Appeal Decision

Appeal Ref: APP/C3810/A/11/2158287
18 Durban Road, Bognor Regis PO22 9QT

- The appeal is made under section 78 of the Town and Country Planning Act 1990 against a refusal to grant outline planning permission.
 - The appeal is made by P Hudson and P Meredith against the decision of Arun District Council.
 - The application Ref BR/341/10, dated 3 November 2010, was refused by notice dated 26 May 2011.
 - The development proposed is demolition of derelict 2 storey office building and erection of 8 No 2 bed flats and 6 No 1 bed flats with ground floor parking bin and cycle storage and children's play area.
-

BLOCK & SITE LAYOUT PLAN

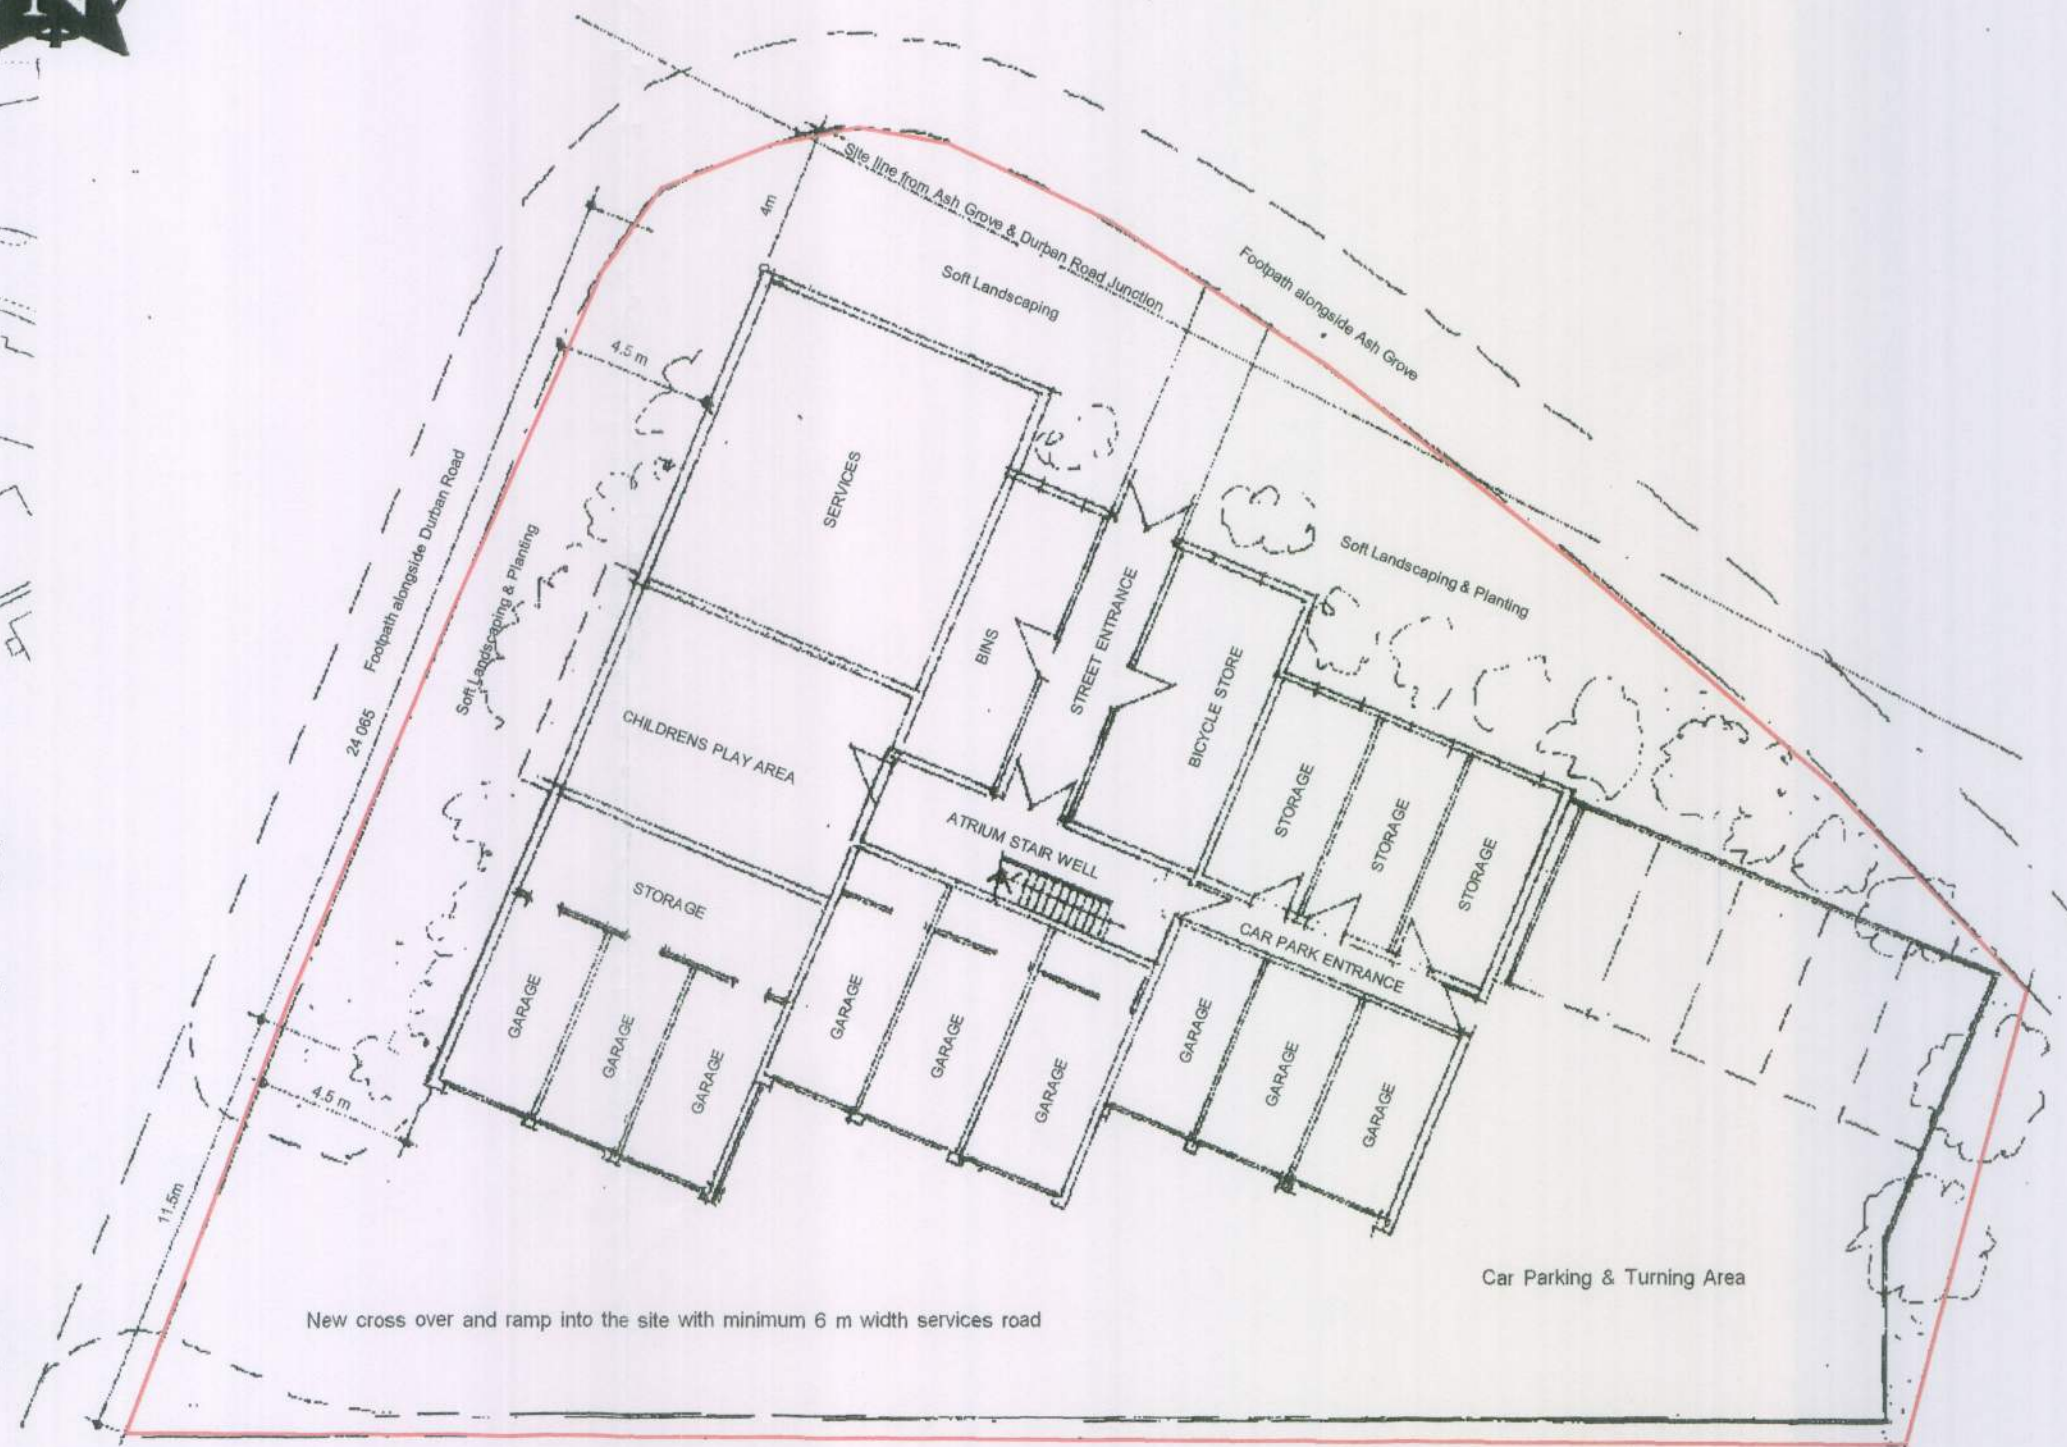
12. The original proposal sought outline consent for 8 one-bedroom and 6 two-bedroom dwellings. The layout shown within the Design and Access Statement shows a three-storey building with a shallow pitched roof. There would be 14 car parking spaces, including 9 garages and ground floor storage for 30 bicycles. The scheme submitted showed a small, enclosed children's play area on the ground floor. The Council consider this to be inadequate for the needs of future occupiers and I concur with this assessment.

13. The revised layout submitted with the appeal attempted to address this issue. It showed an additional amenity area that would abut the parking and storage areas within the site on two sides and the area of soft landscaping and the footway on Ash Grove on the remaining sides. It would be close to a public footpath, which leaves Ash Grove near the eastern boundary to the site. The highway authority has not raised any objection to the amended proposal but has made a number of observations on the practicalities of the layout.

14. The Council does not have specific requirements for the quantity of amenity space in relation to residential development. Nevertheless, it seems to me that even with the revised scheme the area would be small for the number of dwellings. Furthermore, it would reduce the amount of space on the site previously allocated for landscaping, car parking and manoeuvring of vehicles. The amenity area would appear squeezed into a corner where it would either be exposed to view from the street or, as suggested by the appellants, enclosed by boundary fencing. Its proximity to Ash Grove and the public footpath would reduce its usefulness to future residents as somewhere that they could enjoy privacy, peace and quiet. In this respect it would be materially different from the amenity area associated with the recent residential development on the opposite side of Durban Road, where the space was not only larger but also to the rear of the building and away from the public highway.

15. Saved Policy GEN7 of the Arun District Local Plan requires development to create attractive places and spaces with the needs of people in mind, which respect and enhance local distinctiveness. In my view the proposed amenity area, both in terms of its quantity and quality, would not meet these objectives. Instead it appears to be an after-thought rather than a pleasant place that would adequately serve the needs of future residents. Its location would make it difficult, if not impossible, for any vehicle to manoeuvre in and out of the parking space adjacent to the eastern boundary as well as reducing

the area available for vehicles to turn around on the site. In their comments on the revised layout the highway authority has raised both these issues. Furthermore, it would significantly reduce the area available for landscaping the site and would be likely to result in planting being replaced by hard landscaping and fencing. These changes would adversely affect the integration of the development into the surrounding area.

16. These factors combine to demonstrate that the proposed layout would appear cramped and that the proposed amenity area would be unsatisfactory. I therefore conclude that it would be harmful to the living conditions of future residents contrary to Local Plan policy to create attractive spaces that serve the needs of occupiers.
